East Anglia ONE North and East Anglia TWO Offshore Windfarms

Applicants' Comments on SASES' Deadline 7 Submissions

Applicant: East Anglia TWO and East Anglia ONE North Limited
Document Reference: ExA.AS-22.D8.V1
SPR Reference: EA1N_EA2-DWF-ENV-REP-IBR-001017

Date: 25th March 2021
Revision: Version 01
Author: Royal HaskoningDHV

Figure 5: Outline Landscape Mitigation Plan and Relevant Heritage Assets in the vicinity of Friston

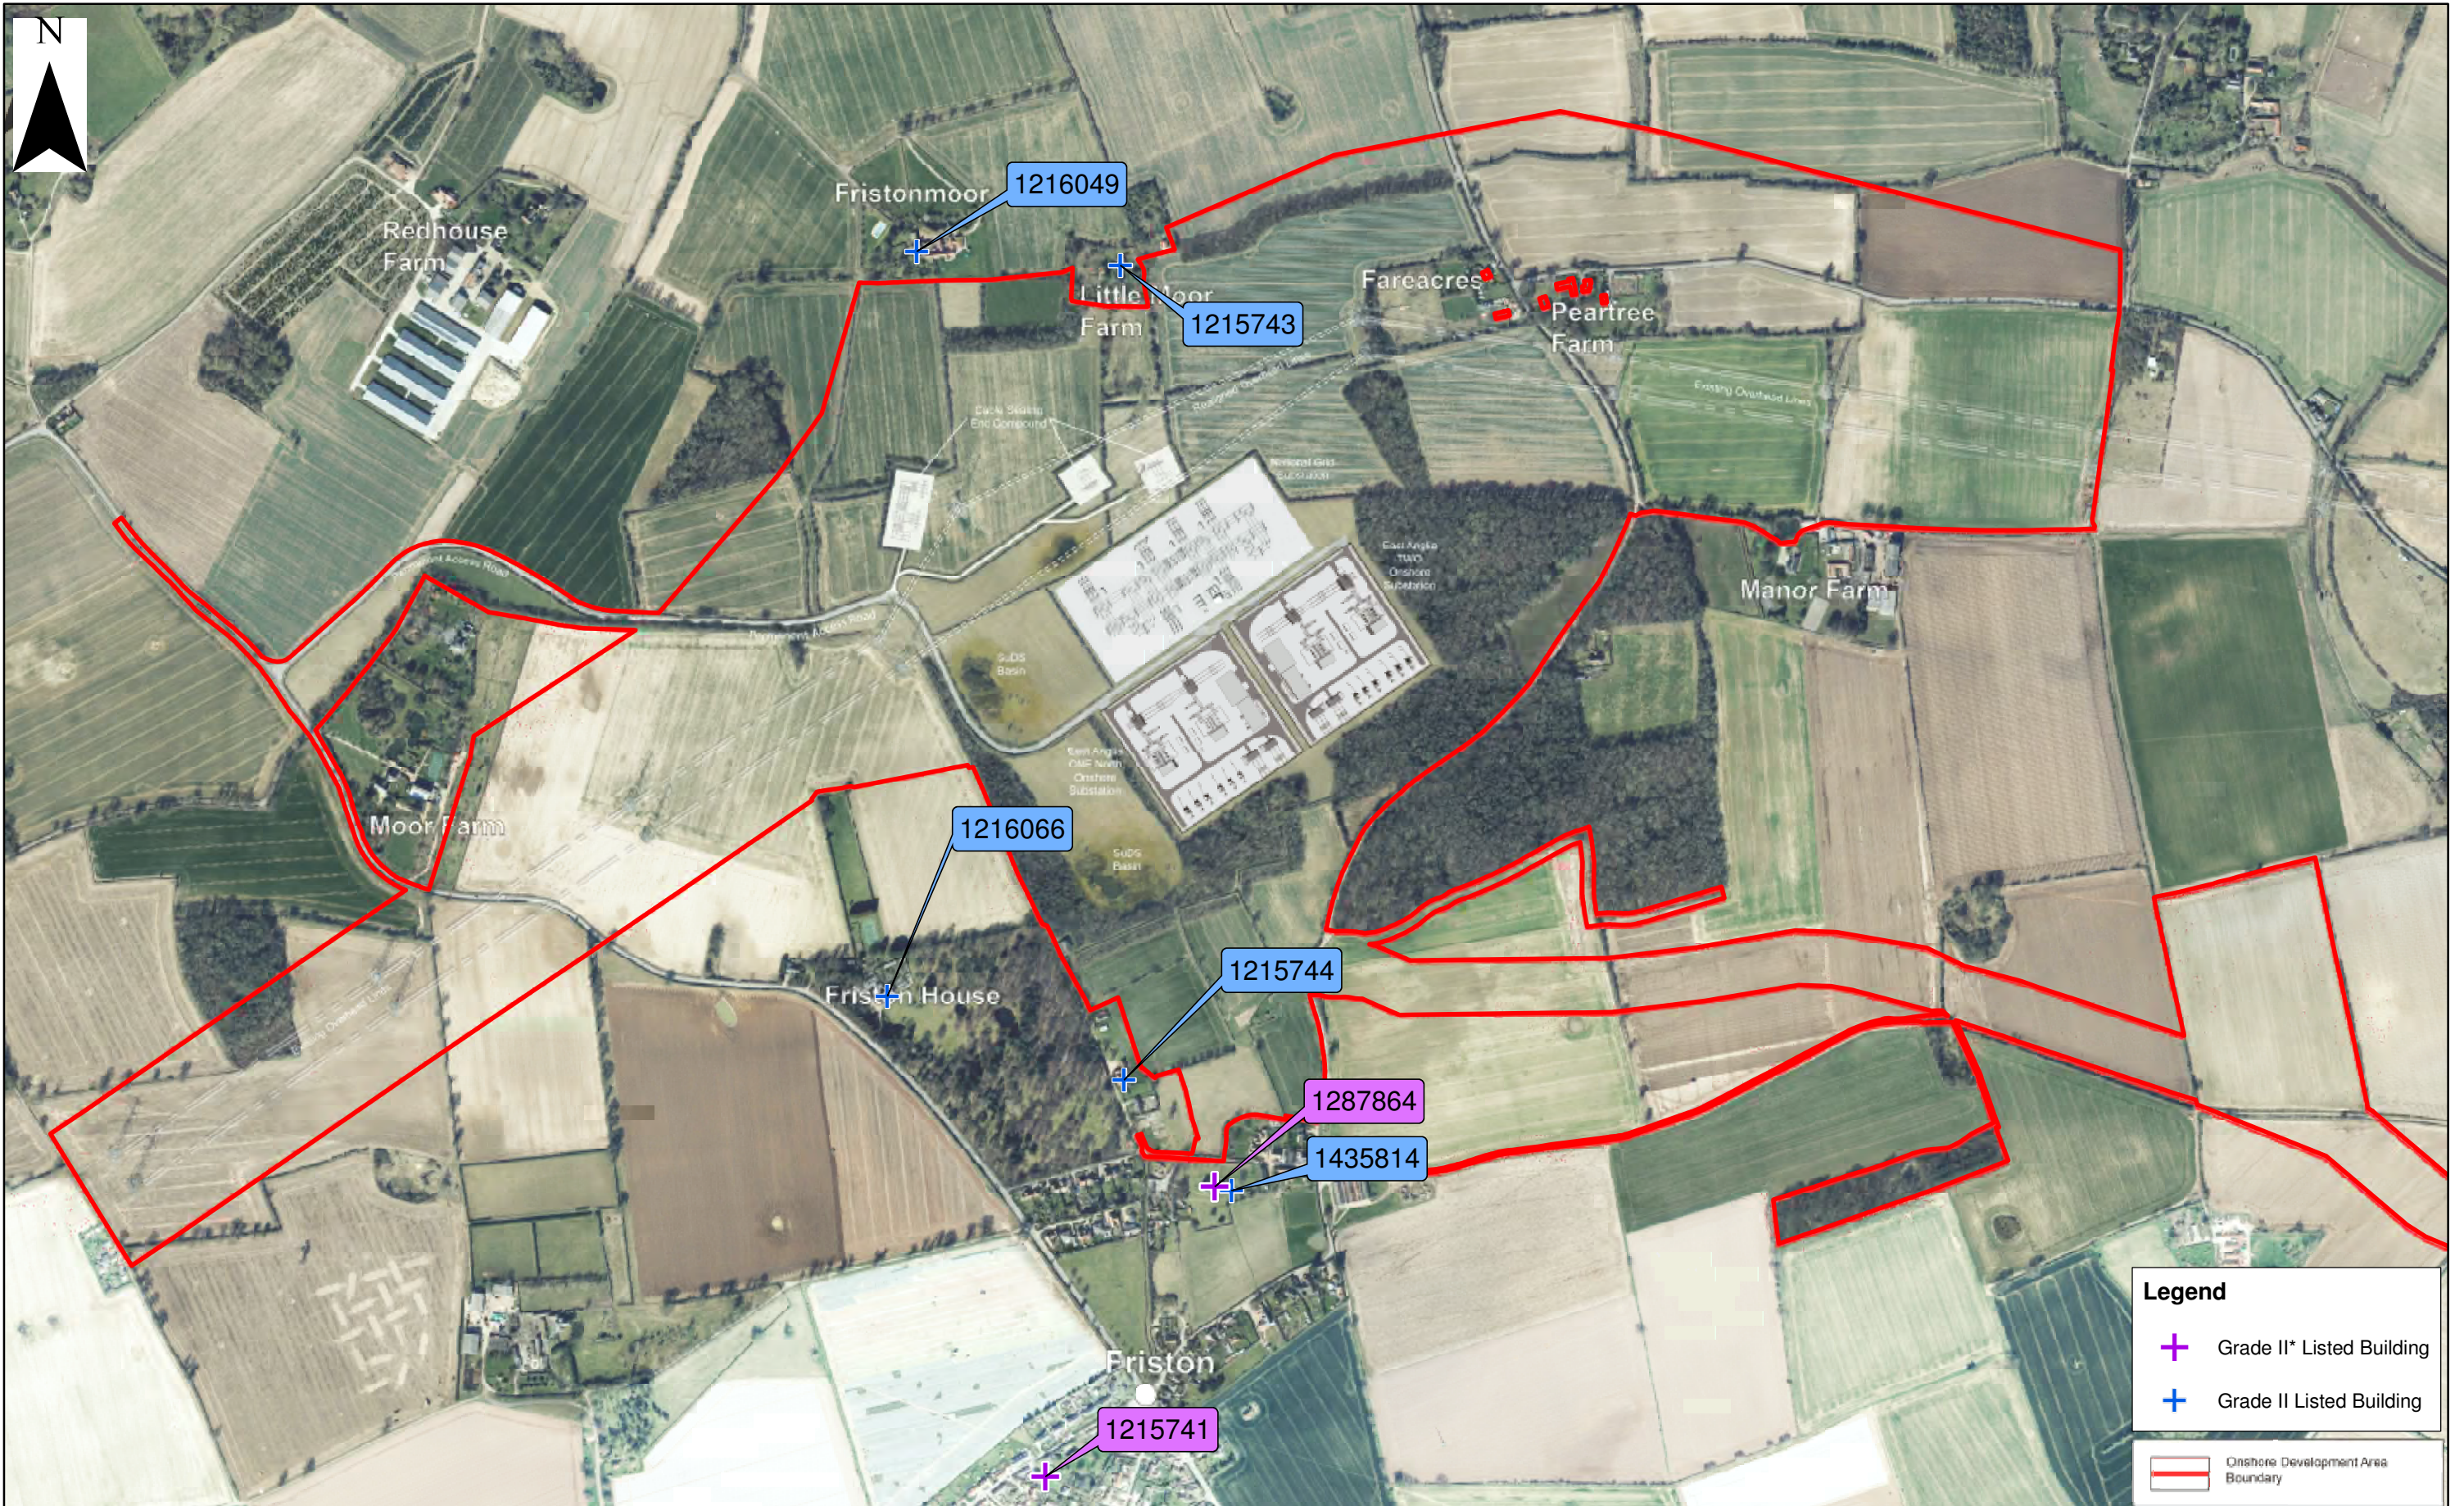
ID	SASES' Comment	Applicants' Comments
	<p>Furthermore, the Applicants' acceptance of the fact that the proposed mitigation planting adjacent to High House Farm will indeed sever the views of the church is a clear indication that the mitigation scheme in itself will also have a detrimental impact upon heritage assets, in addition to the substations and infrastructure themselves. Again, this has been consistently identified by us and other parties as a material concern, in that the proposed mitigation scheme is at best ineffective and at worst harmful.</p> <p>As has been rehearsed in writing and orally, we do not accept the Applicants' position that the views and long-range connection between High House Farm and the church do not add to the significance of either of these heritage assets. On the contrary, the survival of the survival of the complex interrelationship between the heritage assets to the north of Friston is a strong element of the historic landscape character of the proposed development area.</p> <p>The significant change in landscape character proposed to the south of the High House Farm will have a detrimental impact, the scale of which we consider the Applicants has underestimated in their own assessment.</p>

Figure: 8g
CHVP3: PROW between Moor Farm and Little Moor Farm

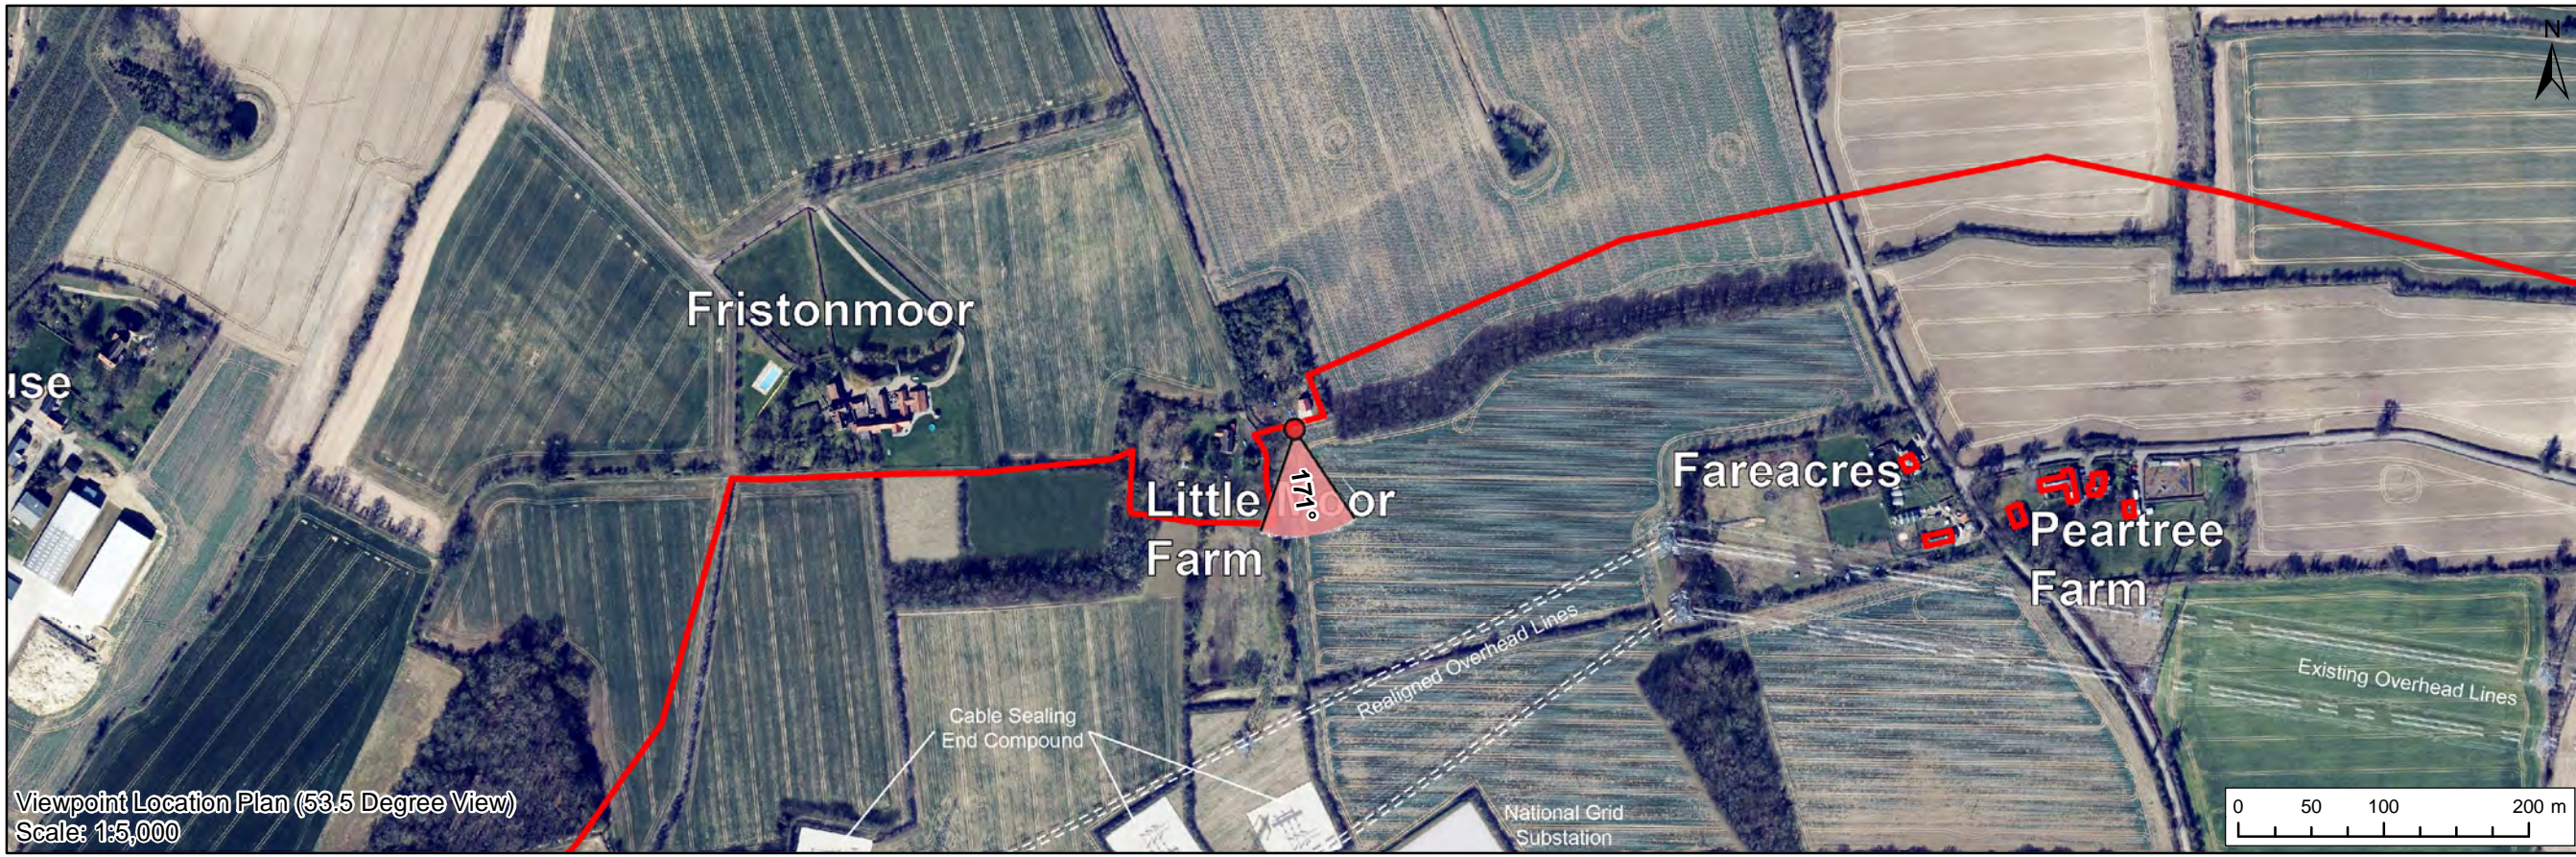
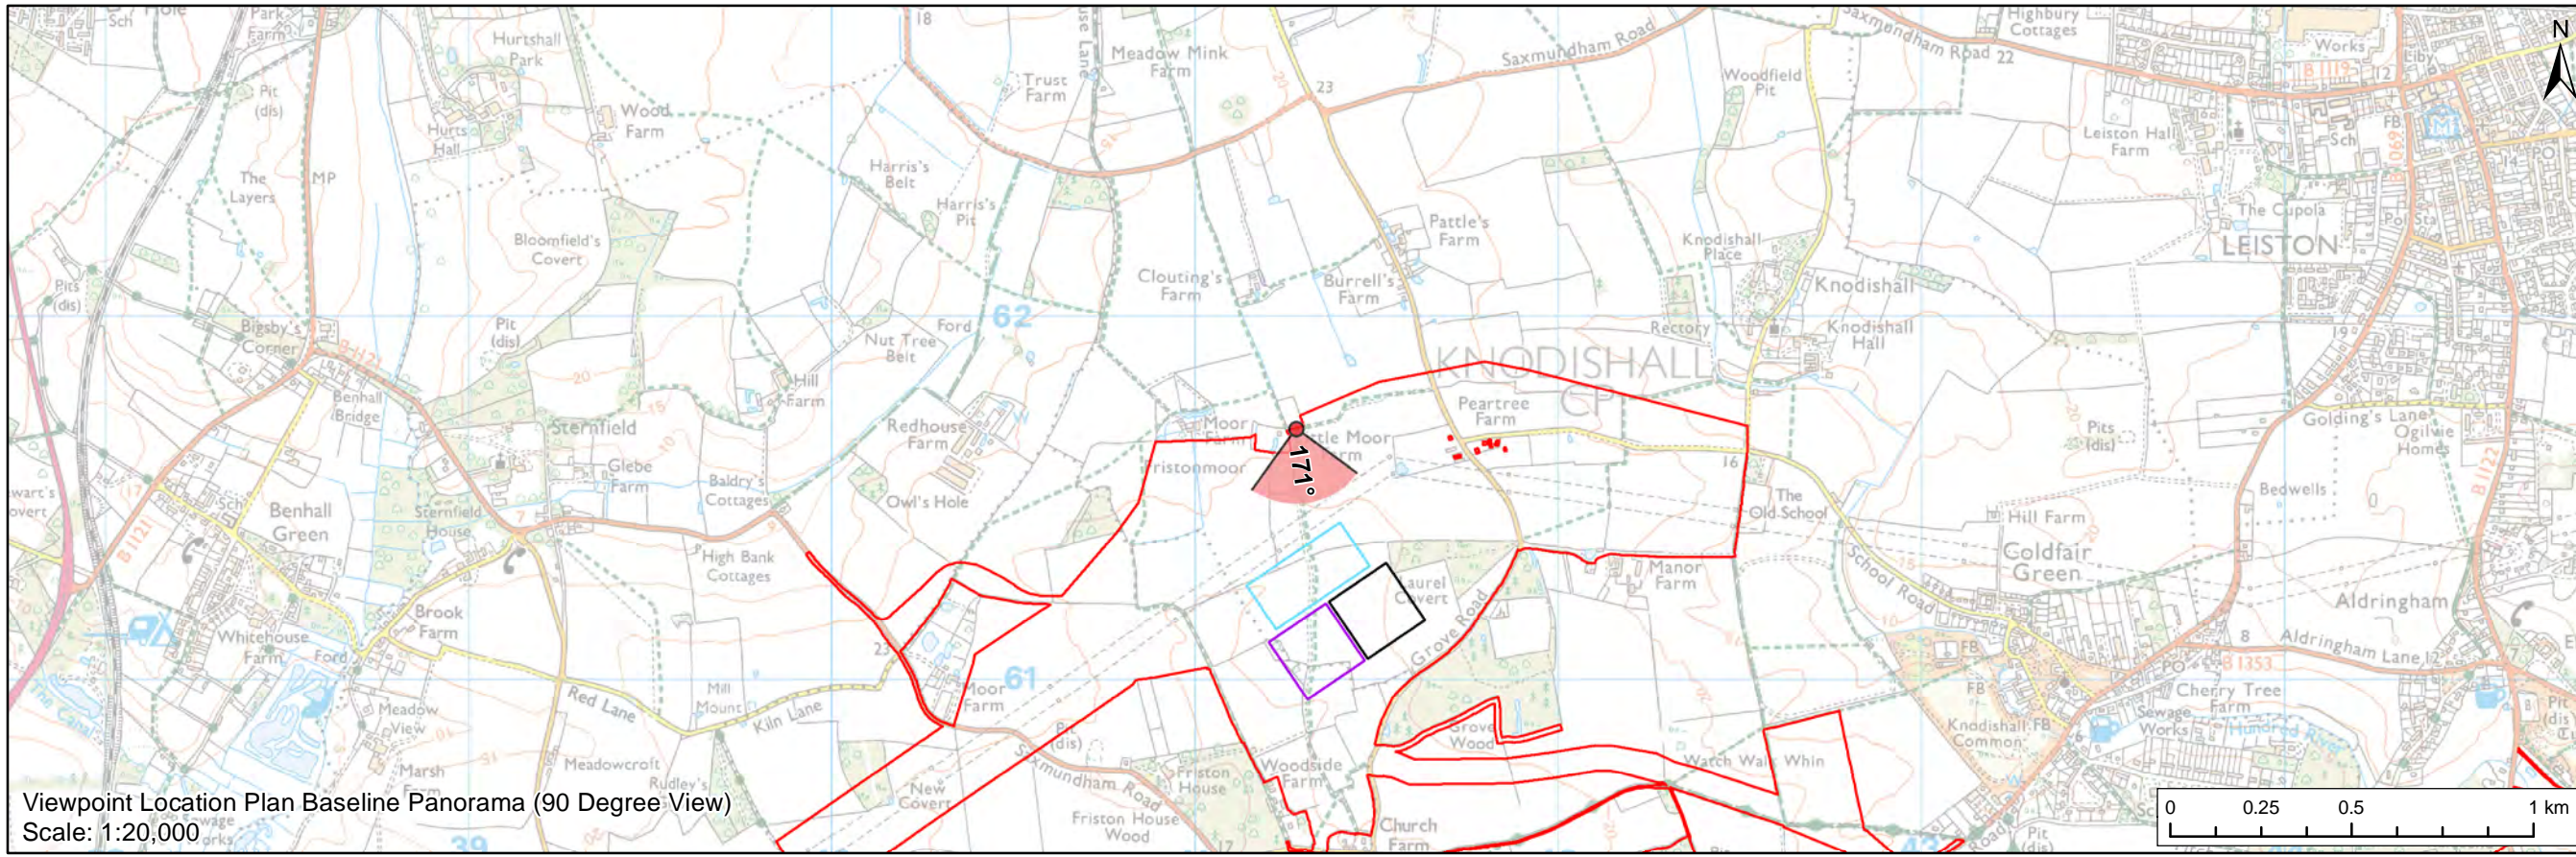
2.8 Historic Environment		
3	<p>2.8.2 High House Farm</p> <p>We welcome the observations made by the ExA in their Question 2.8.2 that viewpoints CHVP3 and VP5 do not represent the view southwards from within the curtilage of High House Farm and that long views are to be appreciated across the open farmland towards the church. Of course, this view is reversed from the church.</p> <p>In their response, the Applicants acknowledge that the curtilage of High House Farm is understood to be cluster of former agricultural buildings, which includes Moor Farm and Friston Barn and their gardens. This represents a much larger and more significant reading of the heritage asset than has previously been acknowledged, with previous assessments focussing on individual buildings rather than the former farm complex as a whole.</p> <p>The submitted visualisations, such as they are, do not support the Applicants' assertion that the construction of the substations and sealing end compounds, the latter being situated between 230m and 275m away, will not sever the connection between High House Farm and the church. We have consistently stated that it will, and this conclusion has been reached by other parties with heritage interests.</p>	The Applicants have no further comments on this matter and would like to refer back to the <i>Heritage Assessment Addendum</i> (REP4-006) <i>Landscape and Visual Impact Assessment Addendum</i> (REP4-031).
